Application number: 2022/91911	
What is the application for?:	Erection of residential development consisting of 47 dwellings with associated h
Address of the site or building:	land at, Cliff Hill, Denby Dale, Huddersfield, HD8
Postcode:	YO19 5LP

Type of comment: An objection	
Do you wish your comments to be published on the website anonymously?	Yes
<p>Having taken time to study all the documents currently available (more seem to be being added!) I am writing to give comments primarily on the many drainage issues raised, as this seems very poorly understood by the developers. Other people have commented on many aspects which I also agree with, and I hope to make some comment on these later.</p> <p><b>EXISTING WATERCOURSE</b> The plans do not take account of an existing watercourse which runs from the paddock at Leak Hall Farm under the public footpath/track emerging under a hawthorn tree around where 'plot 26' is shown on the plans. The trough that this watercourse emerges into is now obscured by brambles, and has been missed in site surveys. It then disappears back underground. We suspect that it runs down to join the watercourse/culvert emerging behind the new houses on Leak Hall

Proposed Section 4-4
Scale 1 : 100

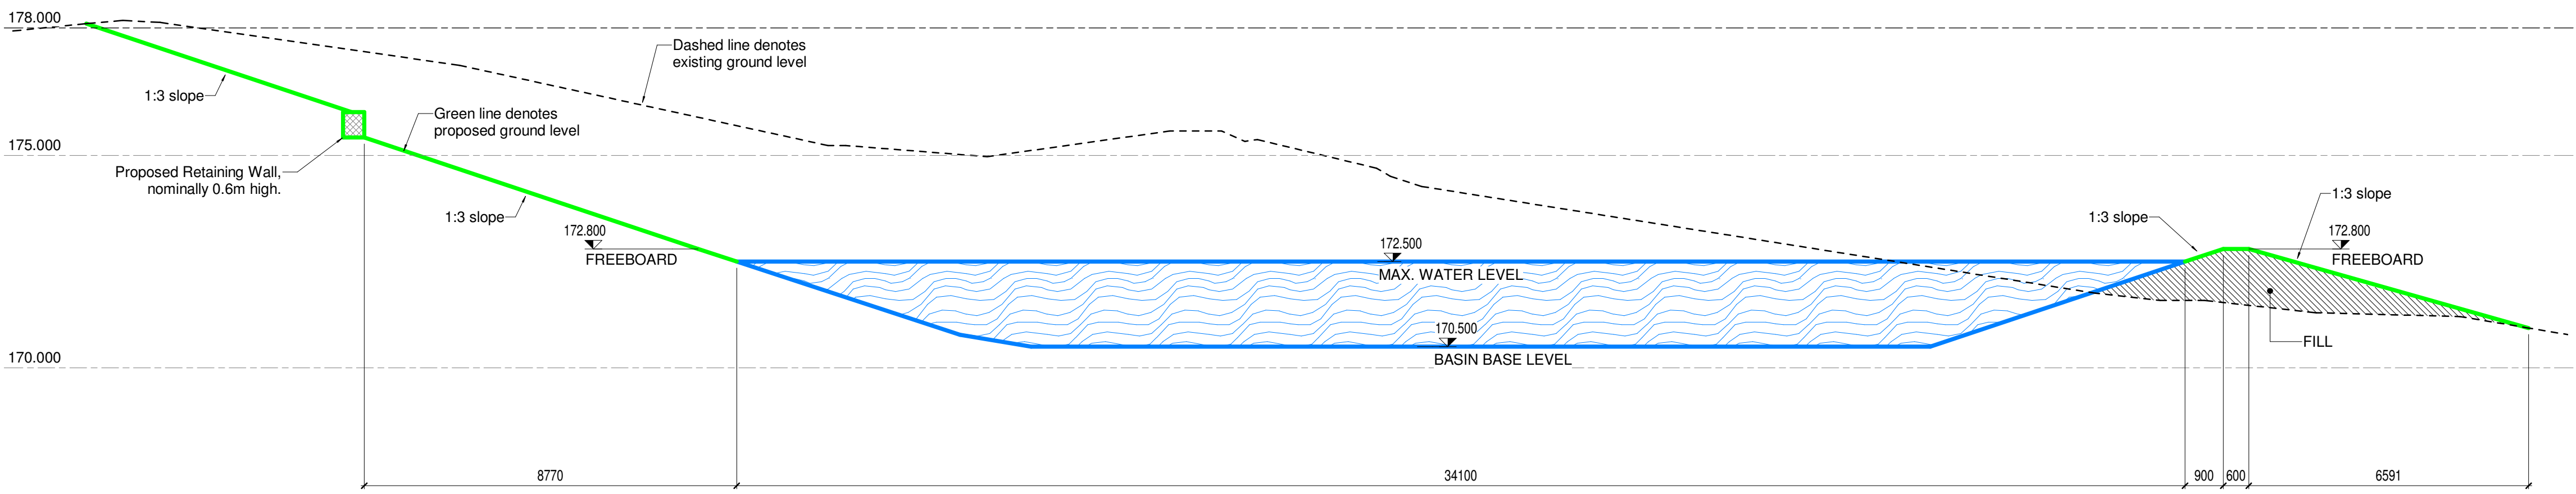
**SUSTAINABLE DRAINAGE:** The SUDS feature raises several issues. The design does not seem likely to form a useful or attractive public open space – as claimed – nor to be a good sustainable drainage solution. The basin has a completely flat bottom, so will always be boggy, if not wet; it may be below the water table. It appears that the basin is surrounded by 1 in 3 slopes and retaining walls, and inlet features. This will limit its use by residents, and if it retains water, could be unsafe for recreation. The landscaping appears to consist of two trees! And will the basin need to be close mown to ensure it remains available to hold maximum water and does not become full of brambles and scrub – who will do this and pay for it?

When full, the water is retained by an engineered bund across the slope, and does not sit within the natural landform. There are houses immediately below this bund, which when full will be holding back 2 metres depth of water – this seems very risky in the short term, when all the land has been disturbed, and in long term. What happens if the bund overflows? Or if it is weakened by foxes, rabbits etc? also, the figures used for run-off calculations are said to be based on a greenfield site, but after the ‘excavation & fill solution’ this will all be made ground not greenfield, with no root zone, no fissures, less percolation and so greatly increased run-off. If the figures are even slightly wrong and the basin is not big enough – this will be a disaster.
